Ribble Valley Borough Council
Council Offices
Church Walk,
Clitheroe
Lancashire
BB7 2RA

Phone: 0300 123 6780
Email: Kathryn.Walsh@lancashire.gov.uk
Your ref: 3/2025/0009
Our ref: 3/2025/0009/HDC/KW
Date: 17 March 2025

Location: Beck House Stoneygate Lane Ribchester PR3 3YN
Proposal: Proposed change of use of annexe (currently known as Beck House Cottage) to separate residential dwelling.
Grid Ref: 364906 435980

Title: Internal Layout Plan

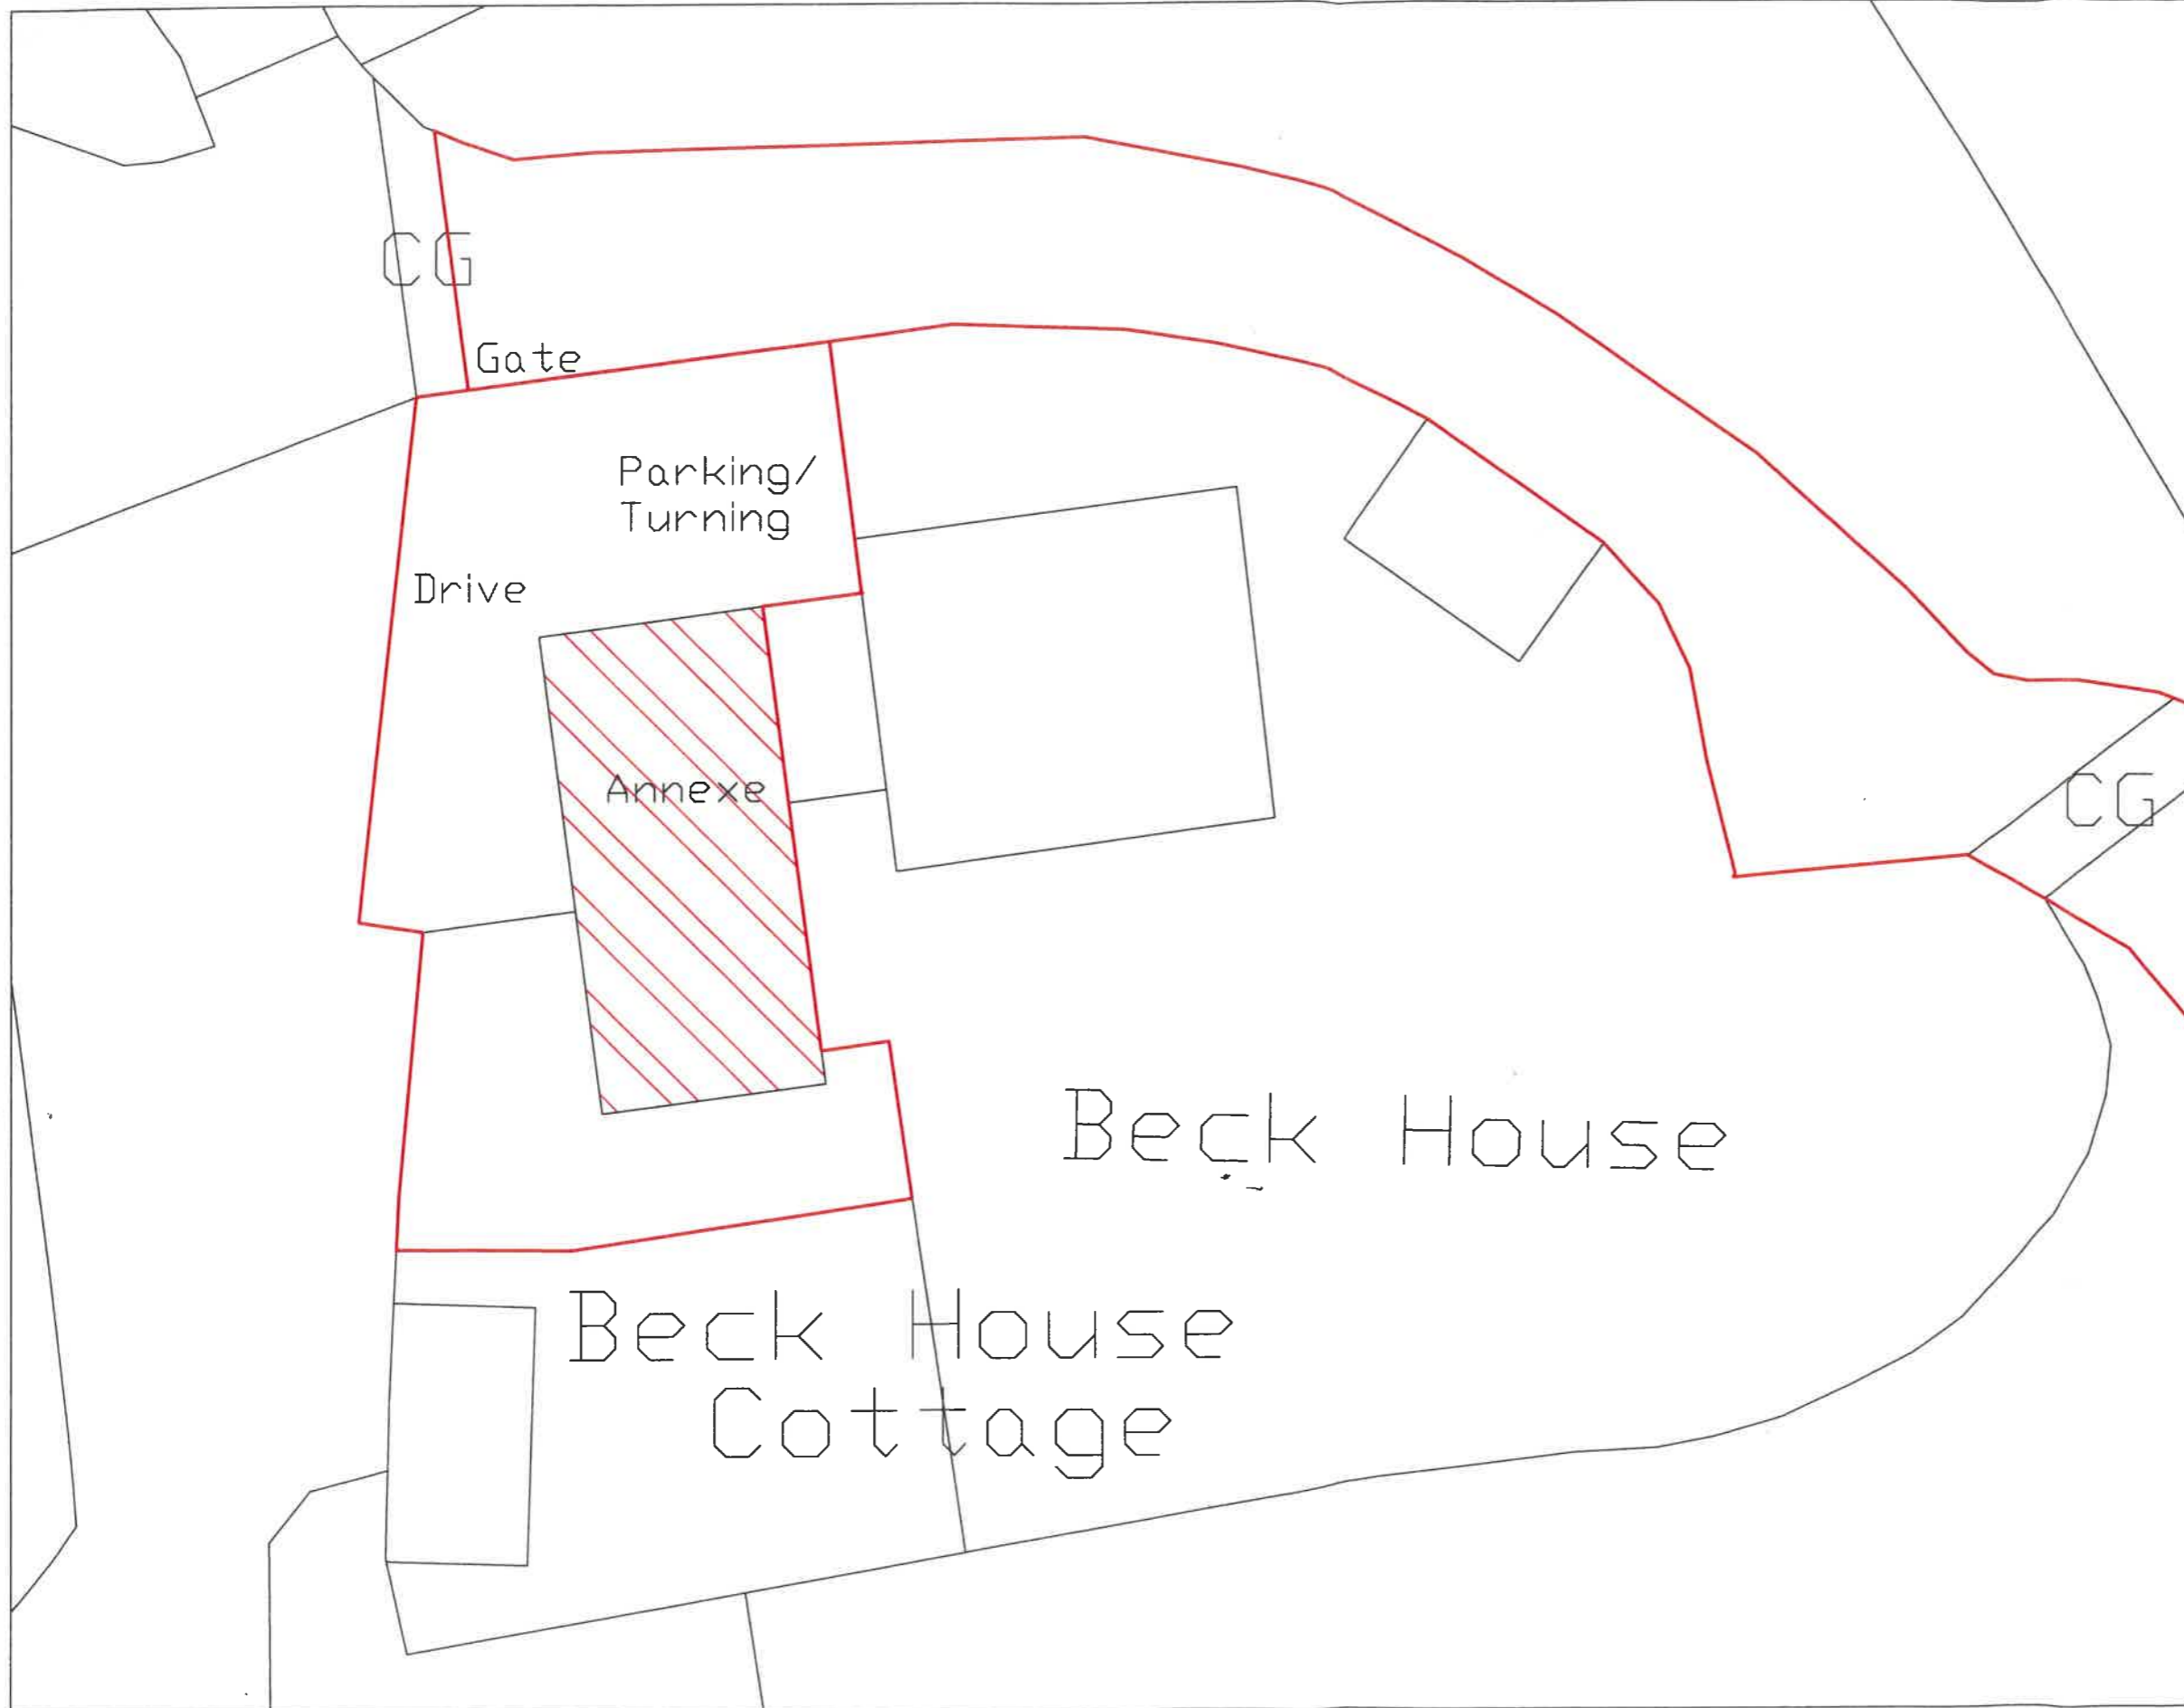
The LHA have reviewed drawing number RTS/415/01/003 titled Internal Layout Plan and are aware that the dwelling complies with the LHAs parking standards as defined in the Joint Lancashire Structure Plan. There is also room to turn allowing ingress and egress in a forward gear. Therefore, the LHA have no objection to the proposal.

1. The development hereby permitted shall not be occupied or brought into use until the car parking and turning areas shown on the approved plan(s) have been provided in full and are available for use. The car parking and turning areas shall thereafter be kept available for the parking and manoeuvring of vehicles at all times.
